Rezoning Transportation Analysis

Petition Number: 2022-155

Date	Description
1-25-23	First Review (TM)
2-23-23	Second Review (TM)

RZ.01

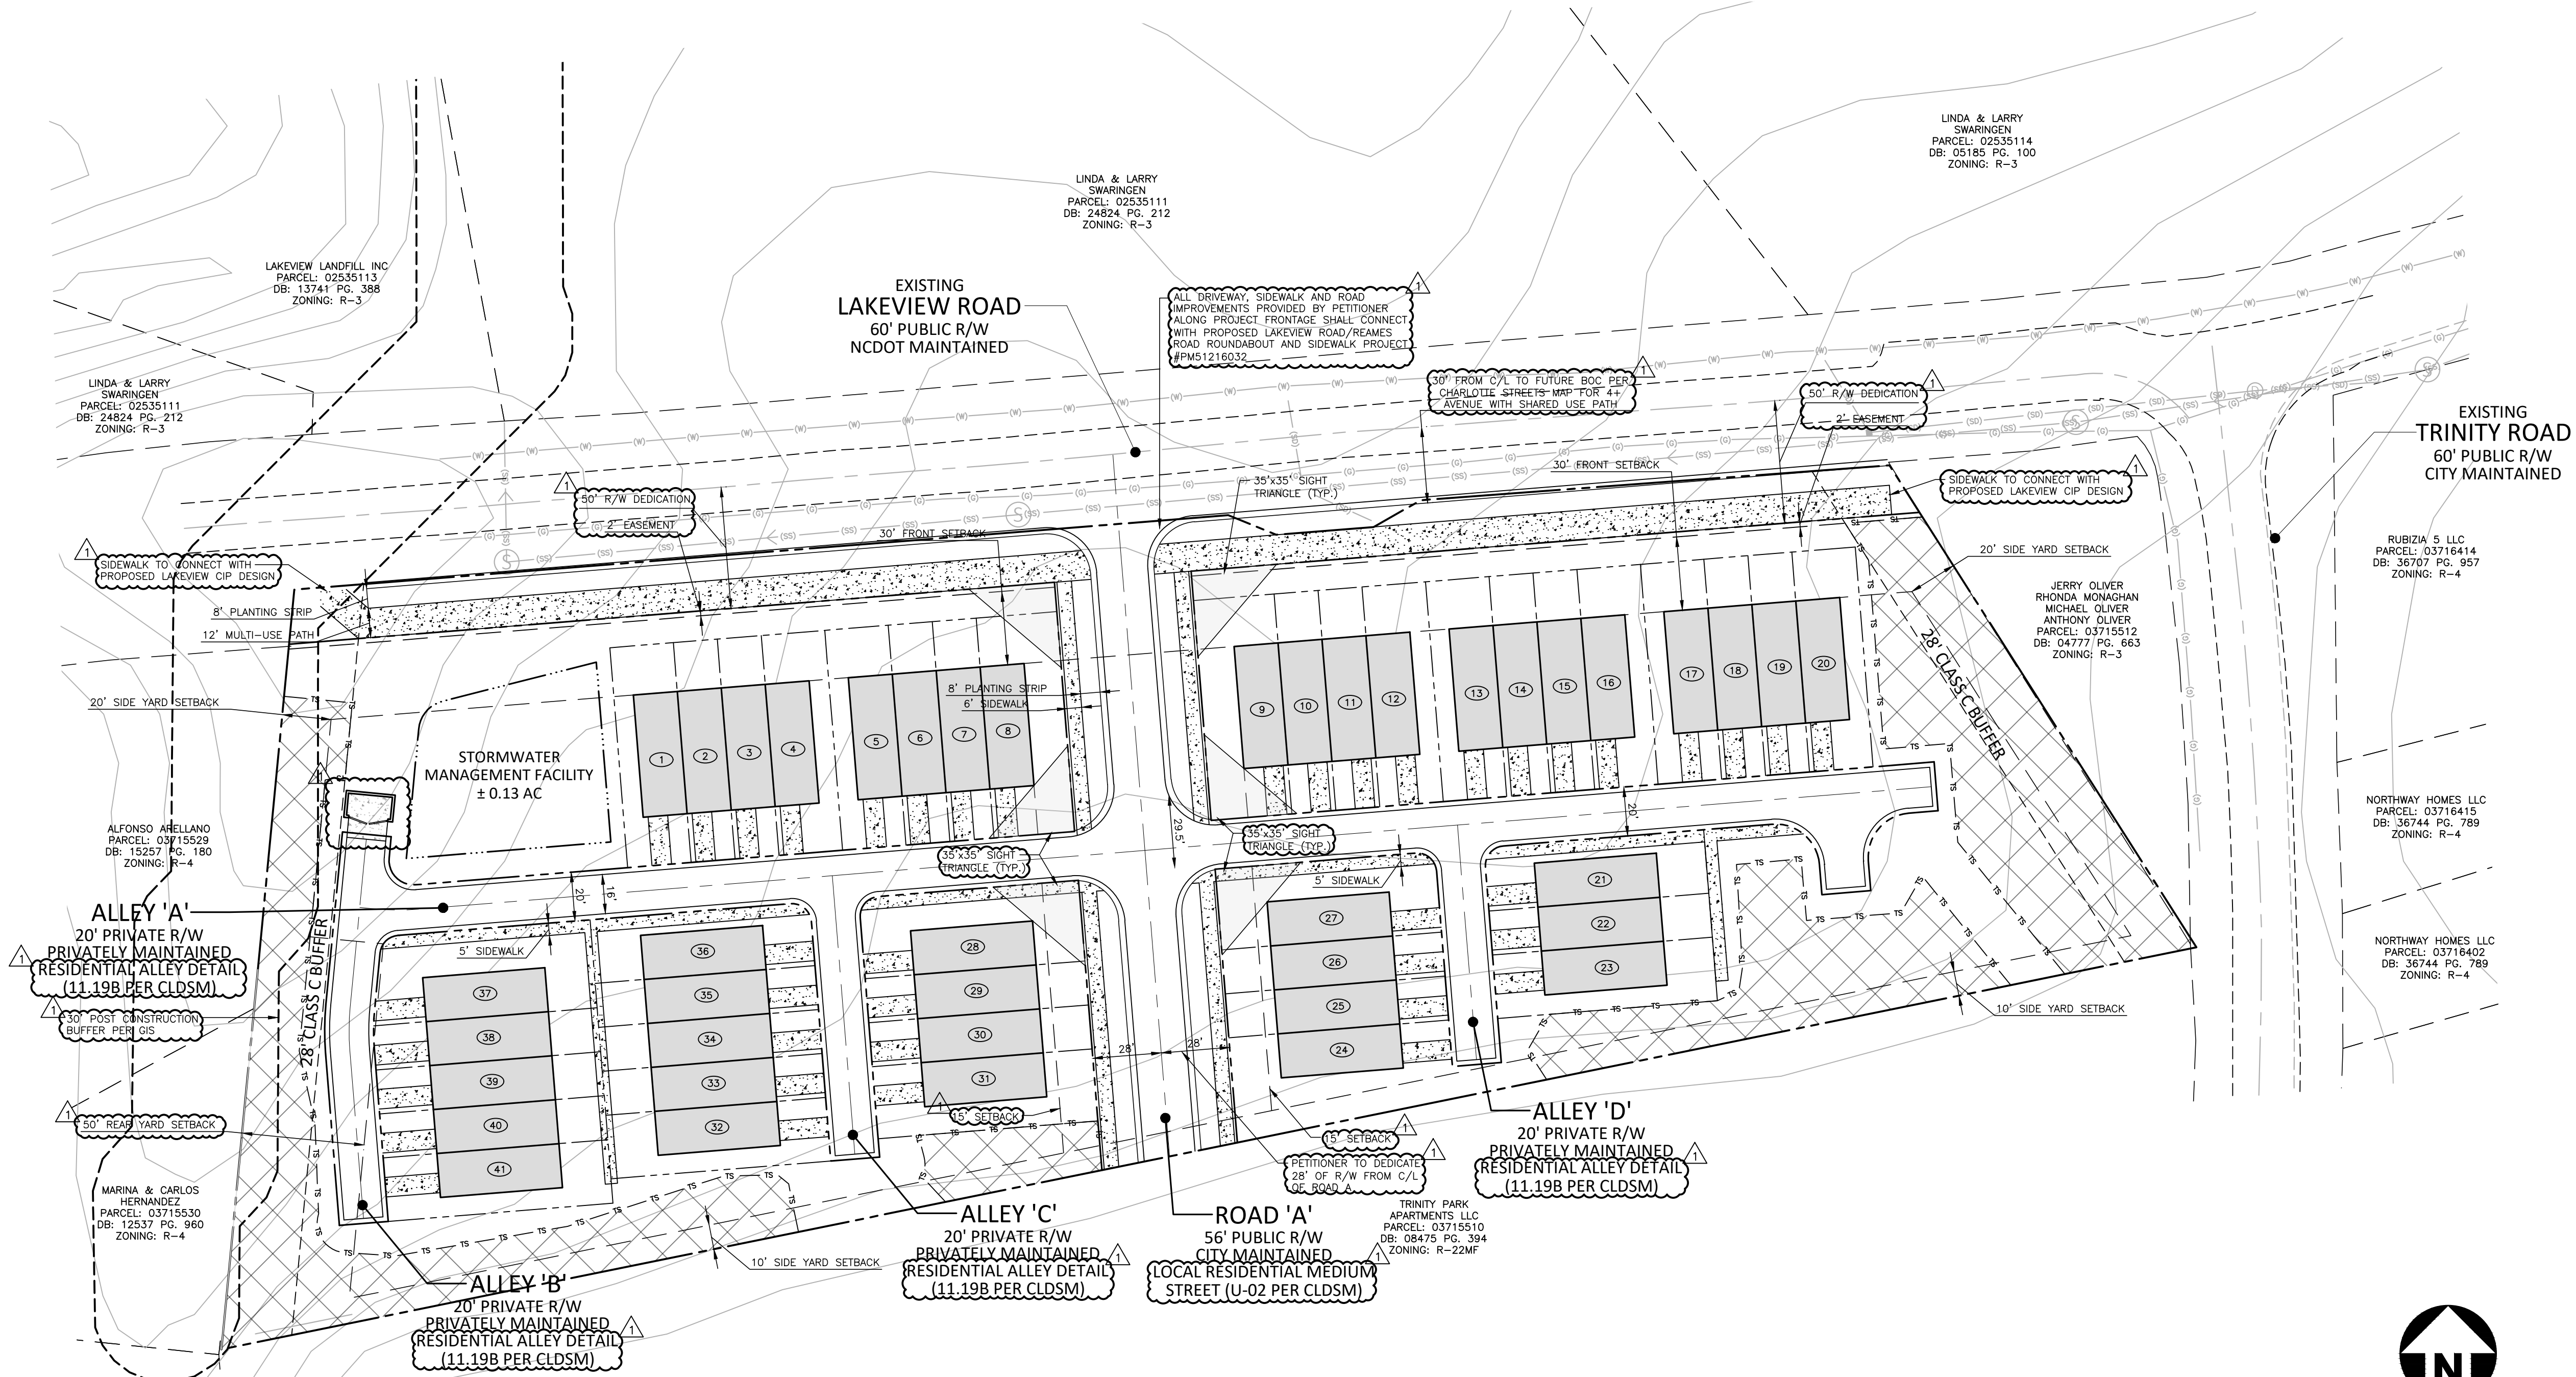
5. **Outstanding Comment from 01-25-23:** Add a conditional note specifying "A Right-of-Way Encroachment Agreement is required for the installation of any non-standard item(s) (irrigation systems, decorative concrete pavement, brick pavers, etc.) within a proposed/existing City-maintained street right-of-way by a private individual, group, business, or homeowner's/business association. An encroachment agreement must be approved by CDOT prior to construction/installation. Contact CDOT for additional information concerning cost, submittal, and liability insurance coverage requirements."

15. CDOT NOTE 02-22-23: Driveways will be required to be moved out of sight triangles.
